Southminster - Campus Repositioning Master Plan
 FOR PUBLIC HEARING Petition No. 2006-028
 Scale: 1" = 60'-0"
 January 20, 2006

DATE: January 8, 2007
 FROM: Debra Campbell, Planning Director
 TO: Gary Huss, Zoning Supervisor

SUBJECT: Administrative Approval for Petition No. 2006-028 by Southminster

**Southminster - Campus Repositioning Master Plan**  
**FOR PUBLIC HEARING** Petition No. 2006-028

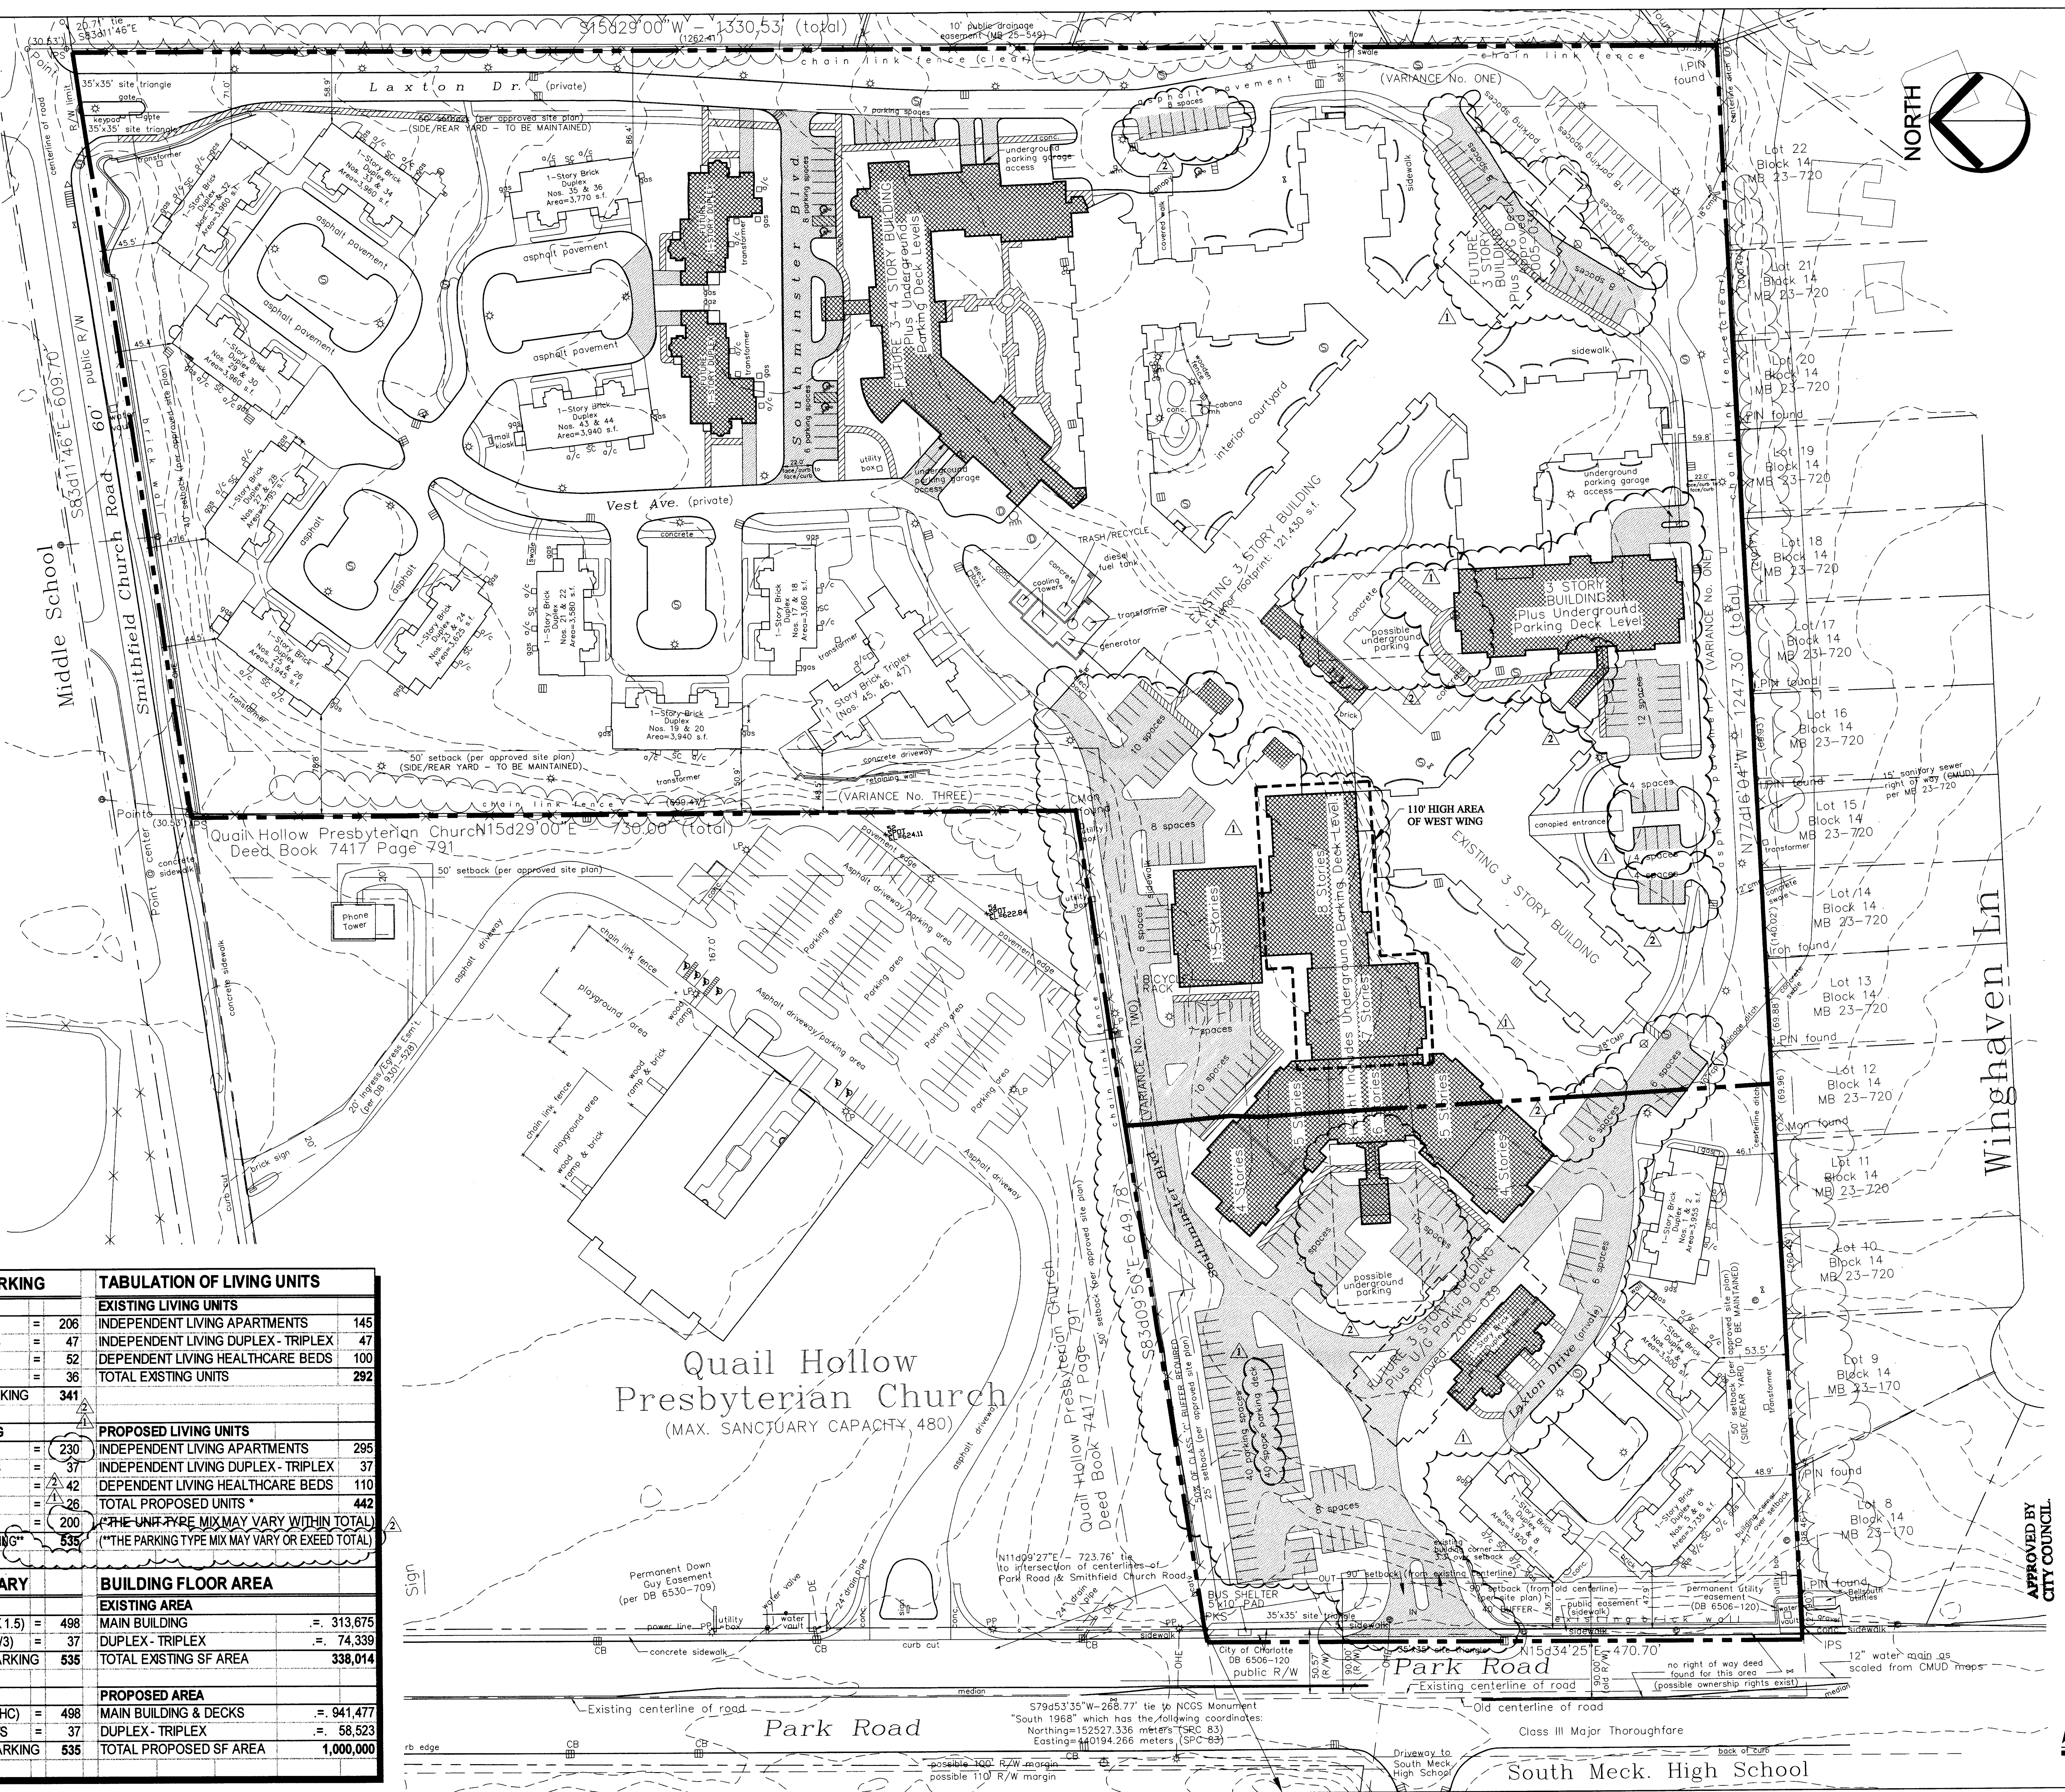
Attached is a revised plan for the above petition. The plan has been revised to increase the width of sidewalks in the parking area in lieu of wheel stops. Since this change is minor, I am administratively approving this revised plan. Please use this plan when evaluating requests for building permits and certificates of occupancy. Note that all other ordinance requirements still apply.

- SIDEWALKS THAT RUN PERPENDICULAR TO AN DIRECTLY ADJACENT TO VEHICULAR PARKING SPACES SHALL BE 7'-0" WIDE TO ACCOMMODATE VEHICLE OVERHANG. PARKING SPACES IN THESE AREAS MAY BE REDUCED TO 17'-0" LONG.
